Office of
Environment
& Heritage

DOC16/242158

Gunlake Quarry extension project (SSD 7090)

Attachment one: Biodiversity comments on the Gunlake Quarry extension project EIS

Figure: Location of Biodiversity Areas

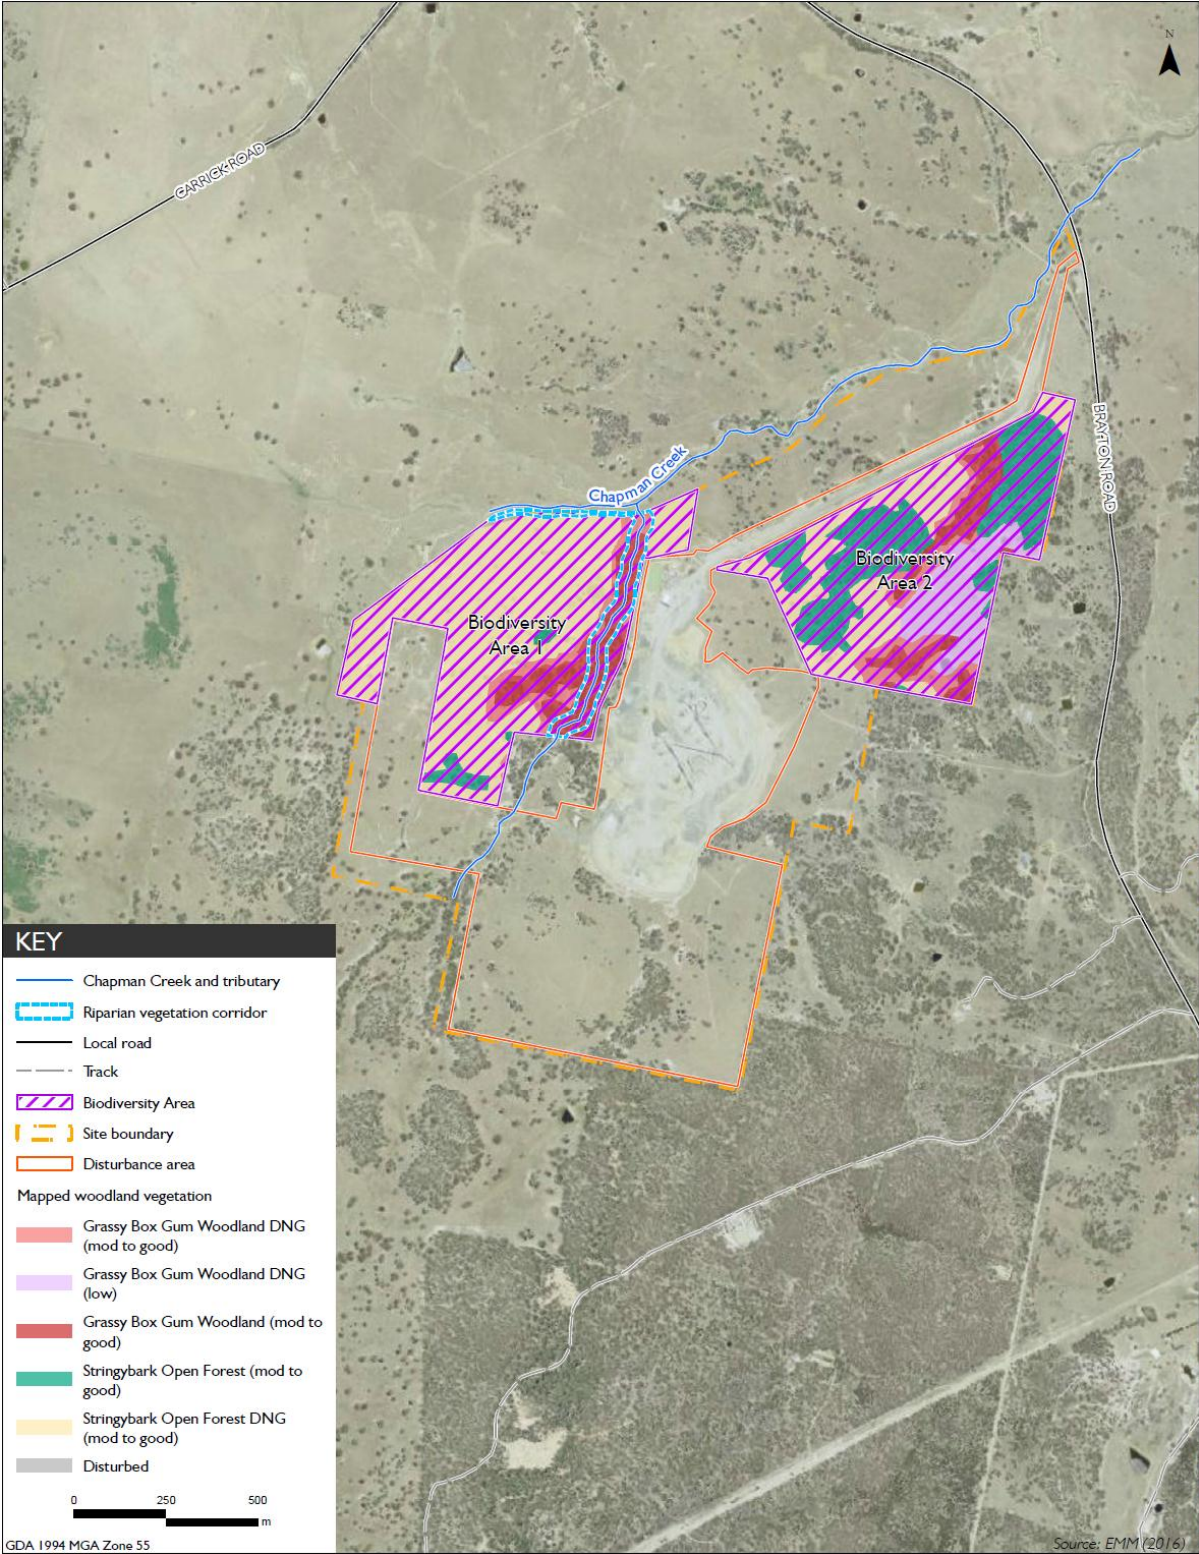
The biodiversity Offset Strategy (section 7 of the BAR) and in particular Figure 7.1 does not identify where offsets for previous approvals (e.g. the original approval and mod 2 approval) are on site – and which sections are intended to fulfil the offsetting requirements for the current proposal. All the offsets are in one lump on a map. Similar to issues described above, the offset strategy does not allow for a transparent review of whether offsets are compliant with current NSW Government policy and/or whether the proponents are "double-dipping".

OEH requires a map and table delineating:

- The location, area and habitat in previously consented offsets (per approval)
- The area and locations of the current offset proposal
